M54- M6 Toll Link Road

Planning Inspectorate Reference: TR010054:

**Summary of Natural England's written representations**

3 November 2020

-DR - LA - 0002

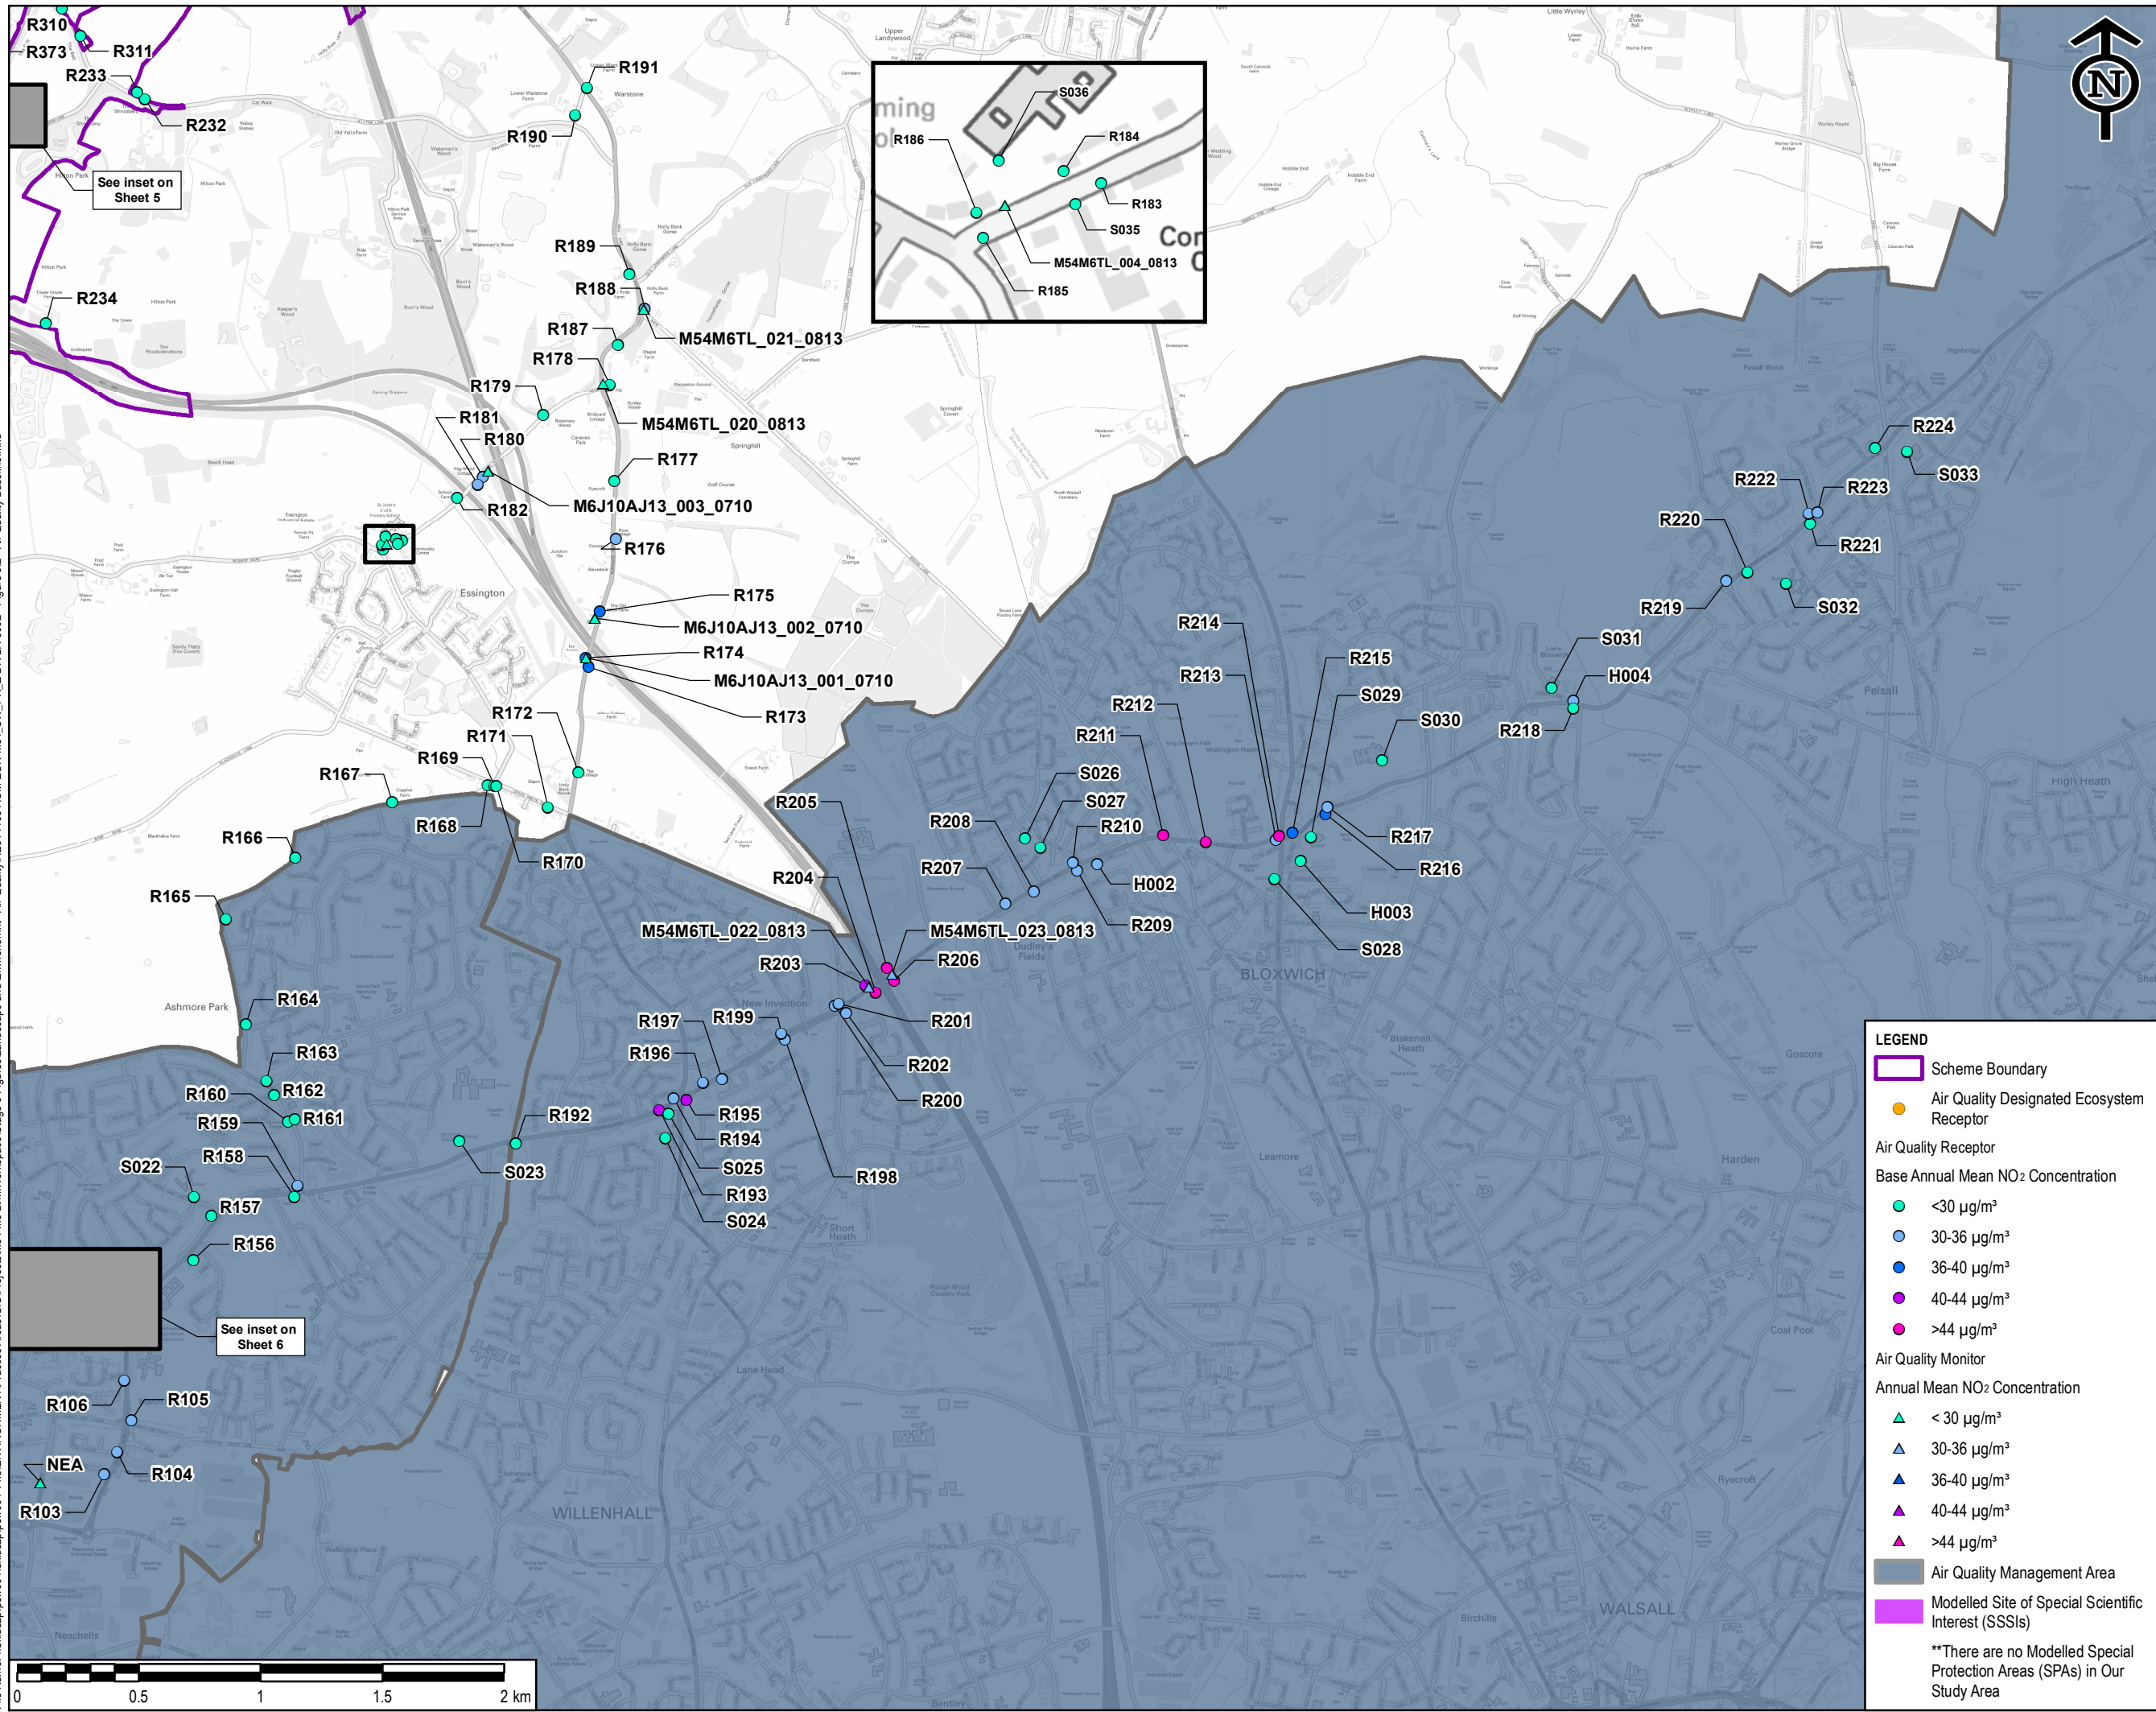
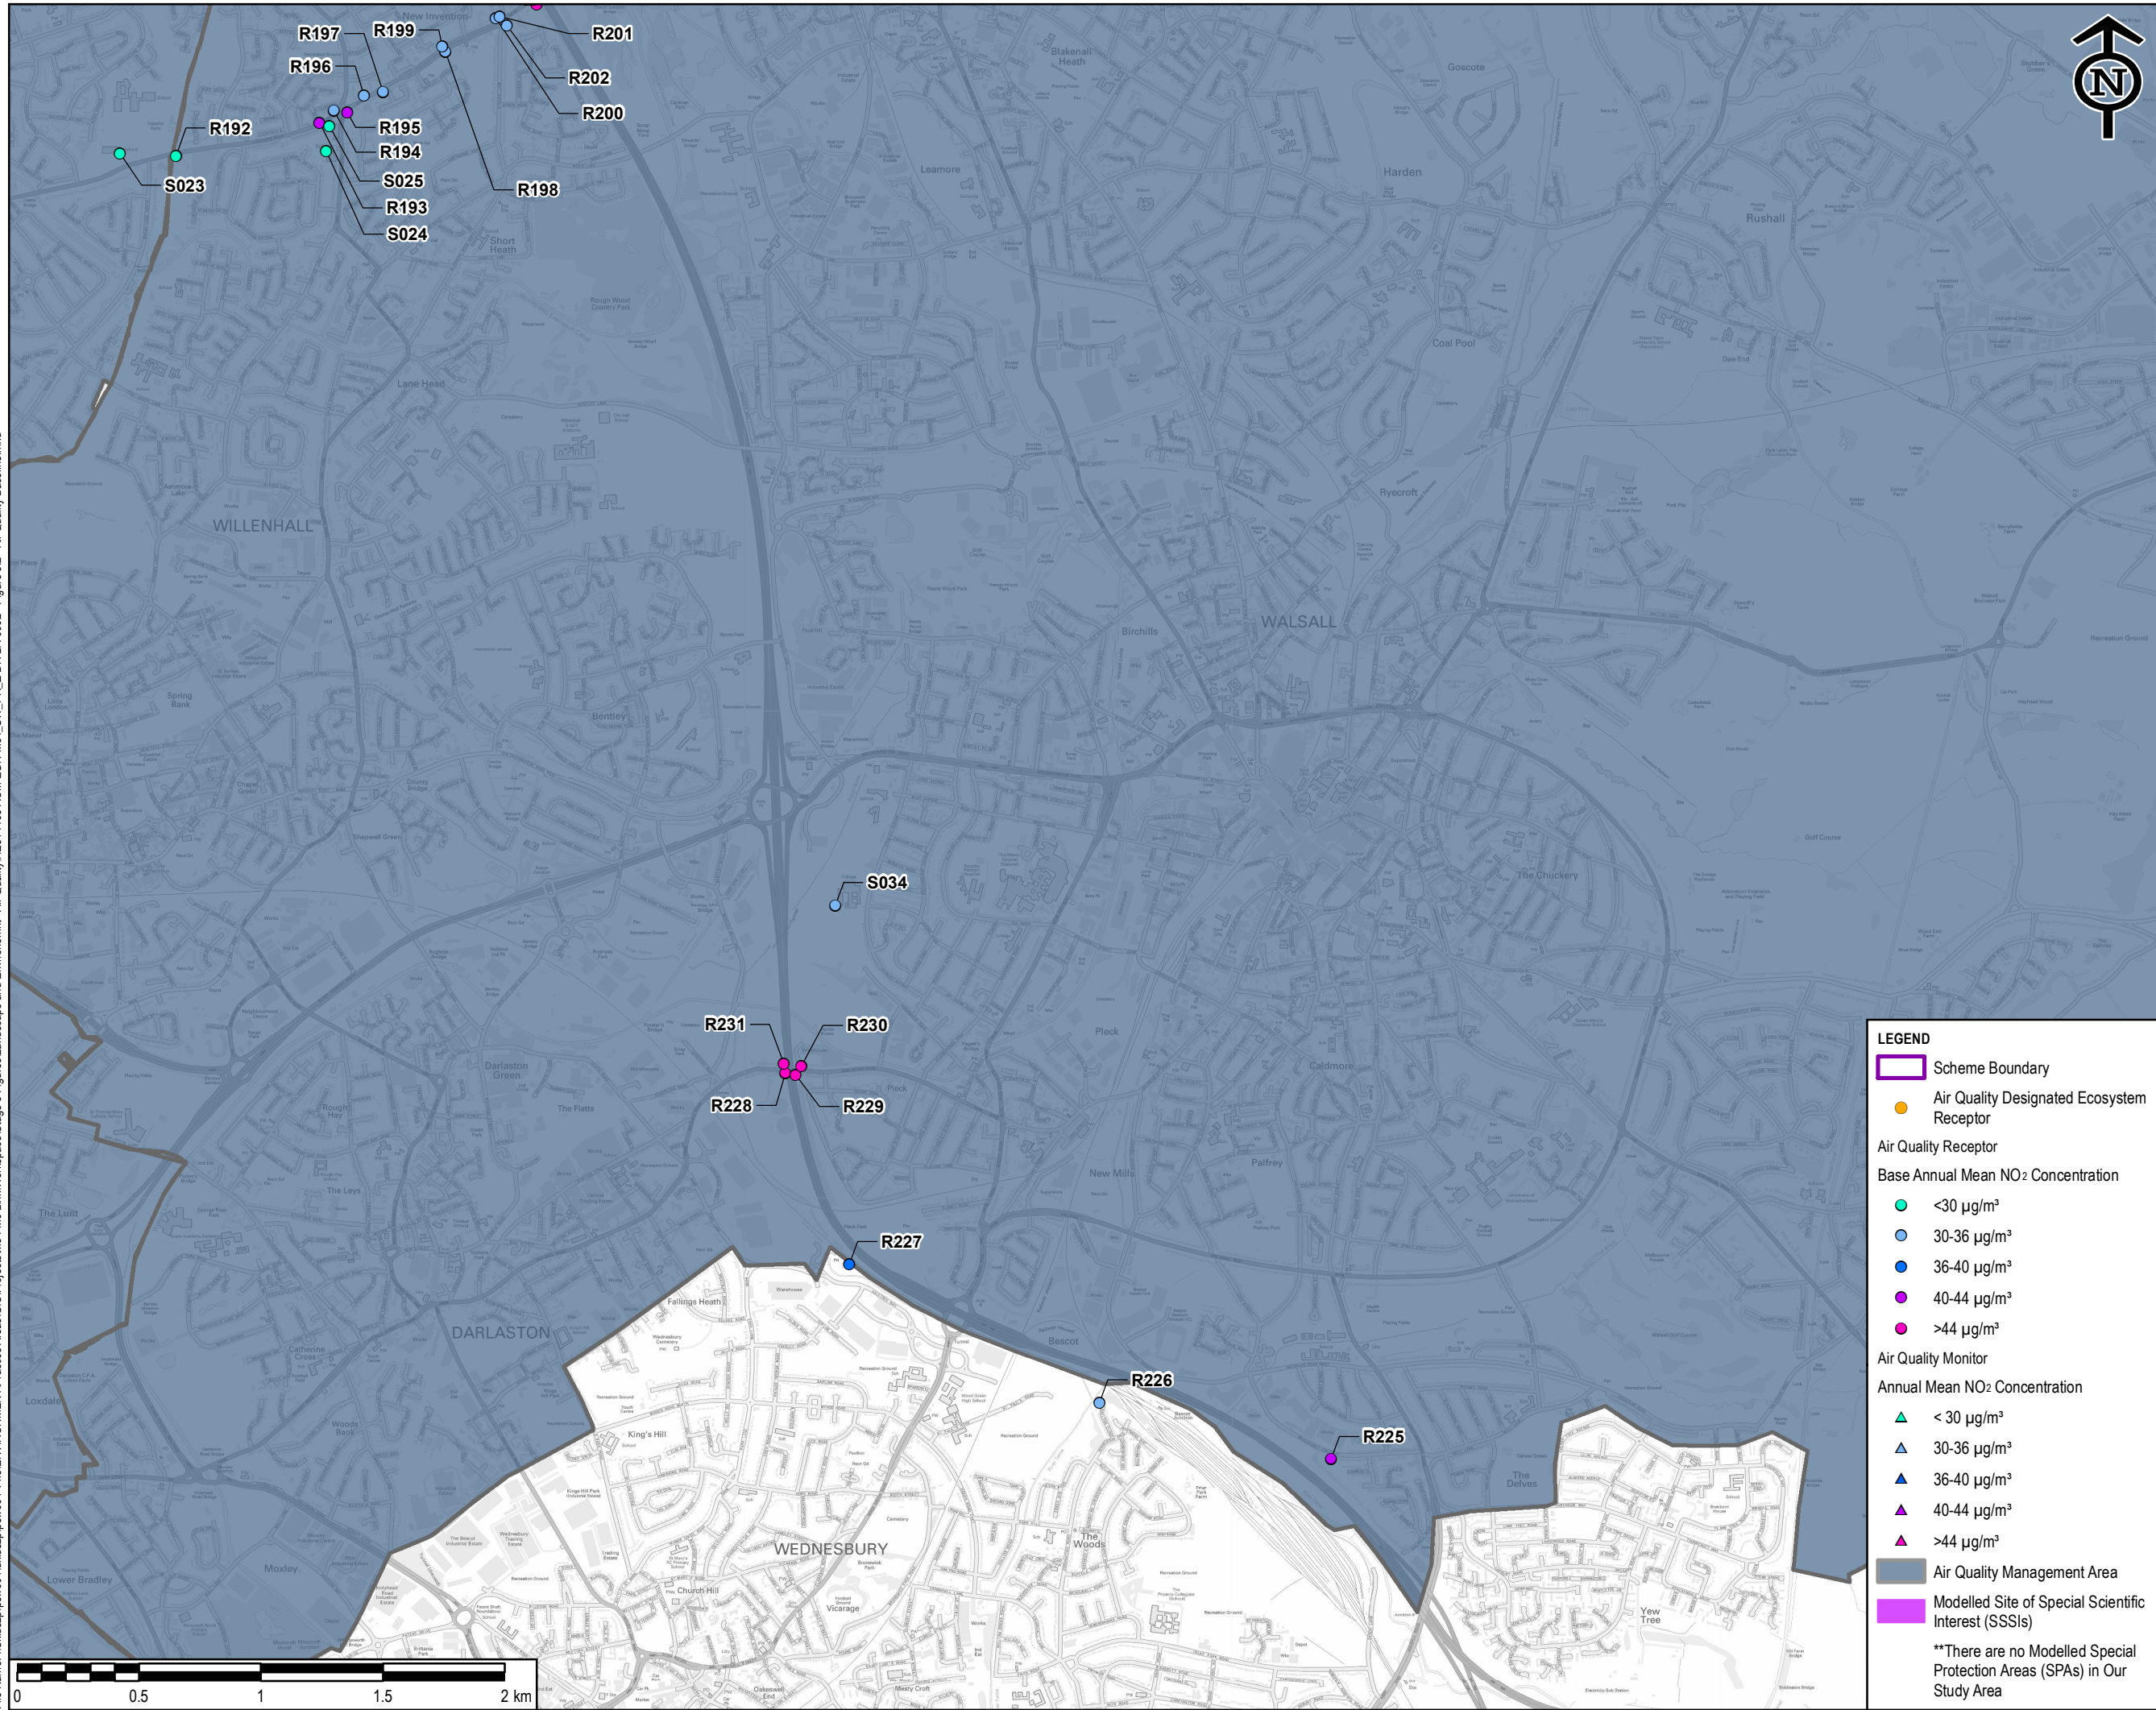
- Confirmation that example sites have been screened out.
      - Indirect impacts require consideration. Cannock Extension Canal SAC is hydrologically linked to Chasewater and Southern Staffordshire Coalfield Heath SSSI, which will be affected by nitrogen deposition.

- 3.2. Nationally designated sites
    - Chasewater and the southern Staffordshire Coalfield Heaths SSSI
    - Stowe Pool and Walkmill Claypit SSSI
      - The scheme would result in increases in NOx and nitrogen deposition at these sites further discussions are required over the assessment and conclusions with regards to potential impacts of these increases (alone and cumulatively) and mitigation.

- Where there is unavoidable loss of ancient woodland the Applicant and Natural England have agreed a ratio of replacement planting and improvement works to Oxden Leasow Wood (also known as Whitgreaves Wood). The detail of the compensation measures requires further discussion.
- Increases in nitrogen deposition on Oxden Leasow Wood and woodland at Brookfield Farm require further discussion on potential impacts on impacts alone and cumulatively.
